**Application** H16-0250-25  
**Location** Monks House Bourne Road Spalding PE11 3LH  
**Proposal** Conversion of loft to habitable space, internal alterations, addition of dormer window to west elevation, re-roof & reinstatement of historic windows

**Name** Spalding & District Civic Society  
**Address** 36 Park Avenue Spalding Lincs PE11 1QX

**Date Submitted** 16-05-25  
**For/Against** Objections

PROJECT TITLE:	MONK'S HOUSE, BOURNE RD, SPALDING		
DRAWING TITLE:	GROUND FLOOR PLANS		
DRAWING NO.:	2548-PP01	REVISION:	-
PAGE SIZE:	A3	SCALE:	1:100

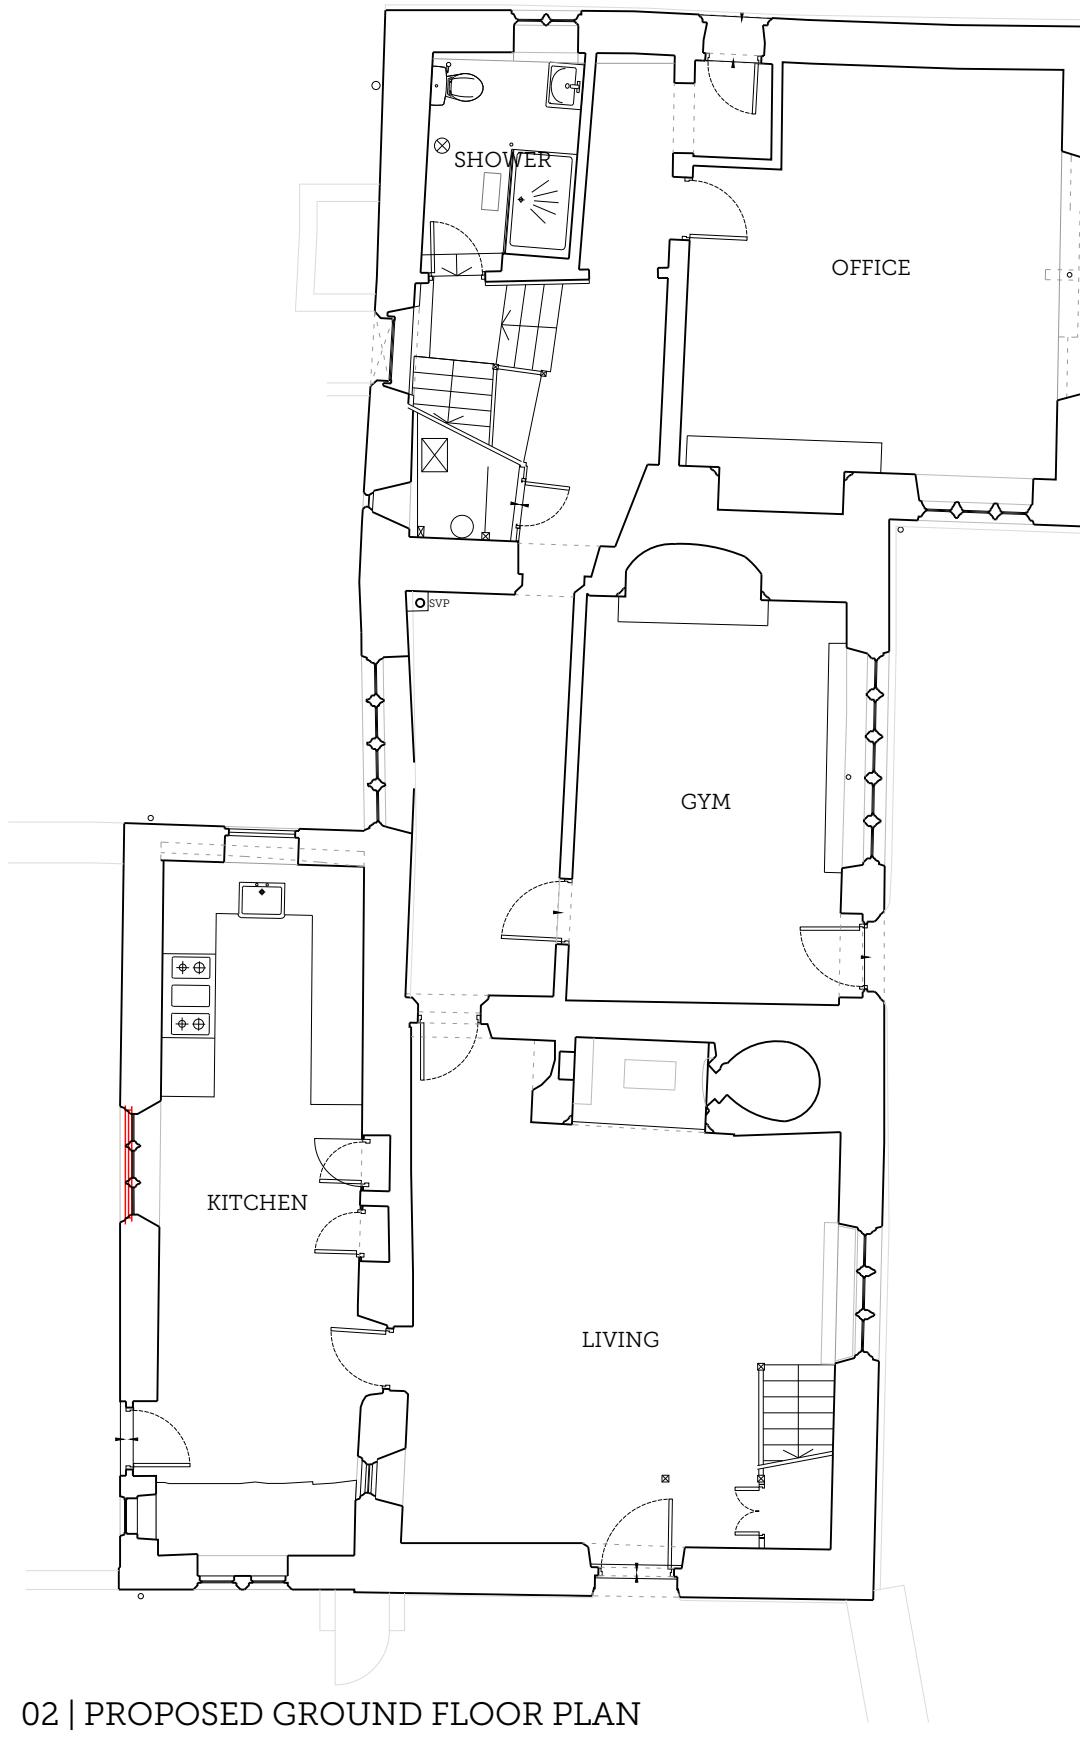
The applicant states that the lack of bedroom space is the main motivation for the loft conversion, yet the design incorporates gym and office space on the ground floor which results in living space being incorporated into the first floor. Could not the layout be reconfigured in some way that might reduce the requirement to convert all of the loft space for bedroom space?

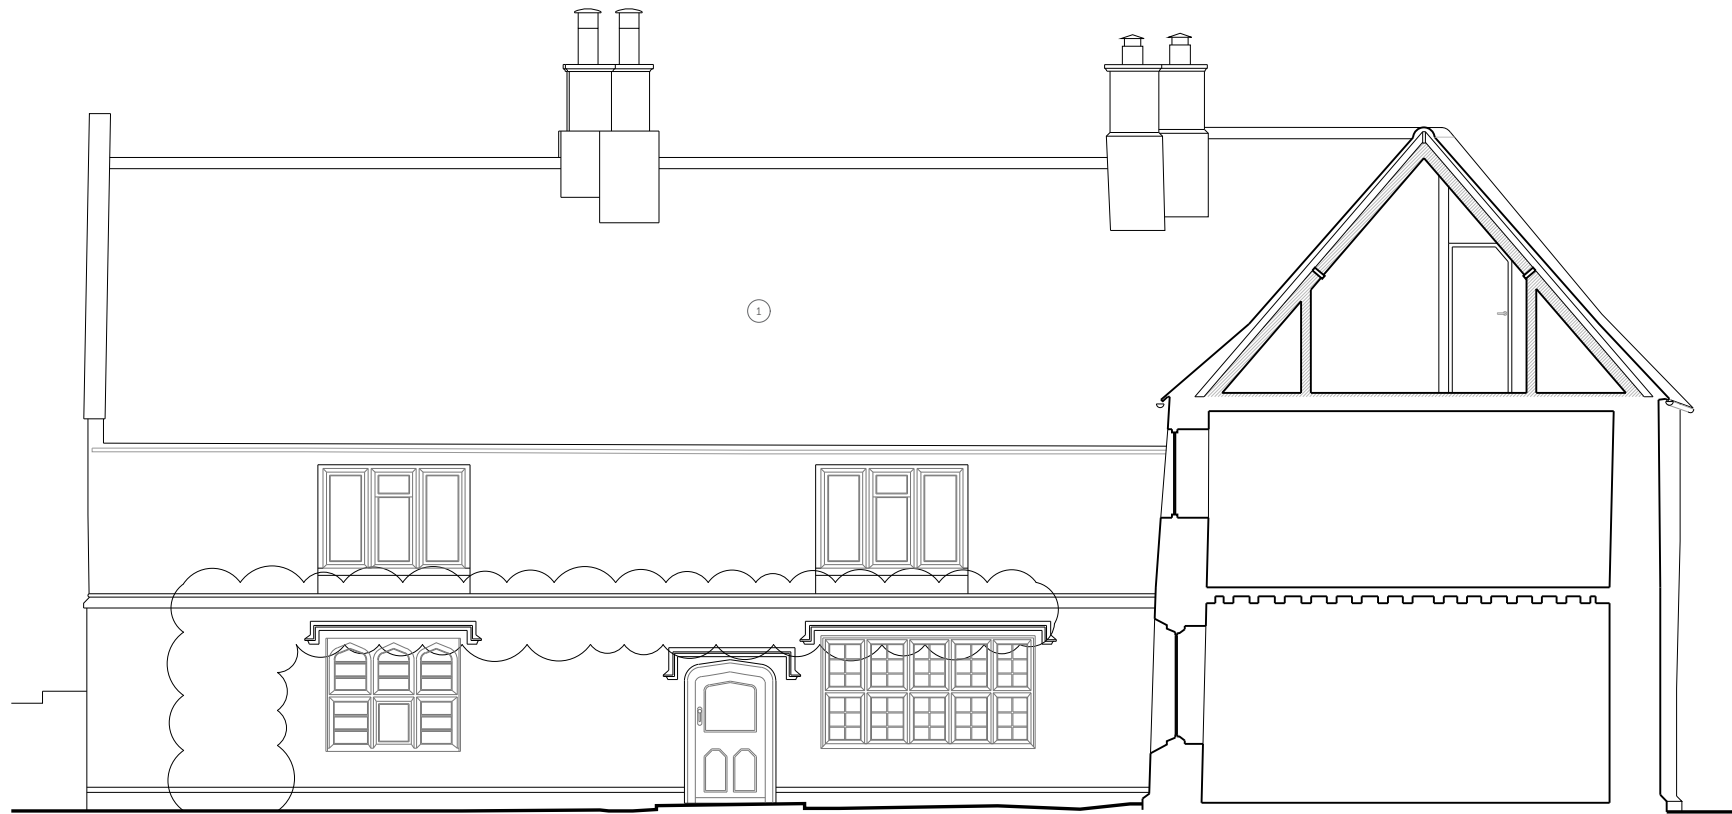
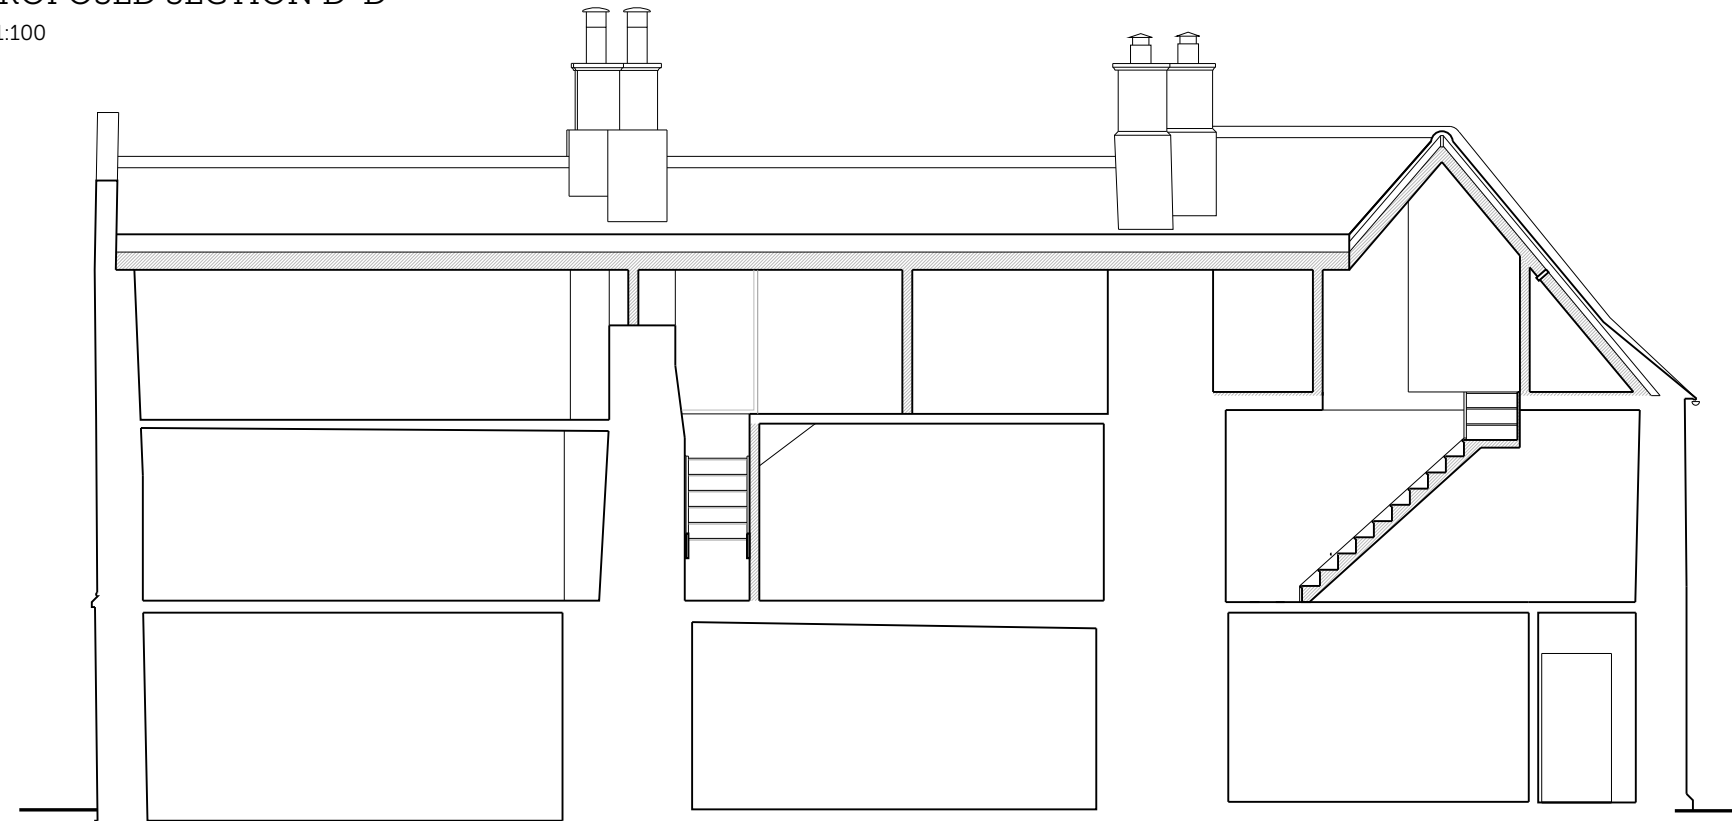
The proposed dormer window seems to serve no other purpose than to provide light onto the landing area. Could alternatives be considered such as a heritage conservation window or sun tunnel windows that would reduce the visual impact of the proposed loft conversion?

Paragraph 5.6 of the Heritage Impact Assessment is headed ALTERATION 4: NEW DORMER WINDOW IN EAST-FACING ROOF SLOPE. However, the text and proposed elevation images suggest that the proposed dormer window is on the west facing slope of the building. We are concerned that the proposed dormer window is too large and would clearly be visible from both the North and South Facing elevations. As such we consider that it contravenes policy 29 of the South East Local Plan at A1. It is an alteration that does prejudice the architectural interest of the building. The proposal also contravenes paragraph 213 of the National Planning Policy Framework that requires justification for harm to the significance of a designated heritage asset from it's alteration to be exceptional. We do not consider that the justification for the proposed dormer window to be exceptional in this case.

The applicant has not indicated how the dormer window might be constructed and of what materials the dormer might be constructed. Without this information and for the reasons stated above, we cannot support the application as it stands, and ask that you note our objection to this application.
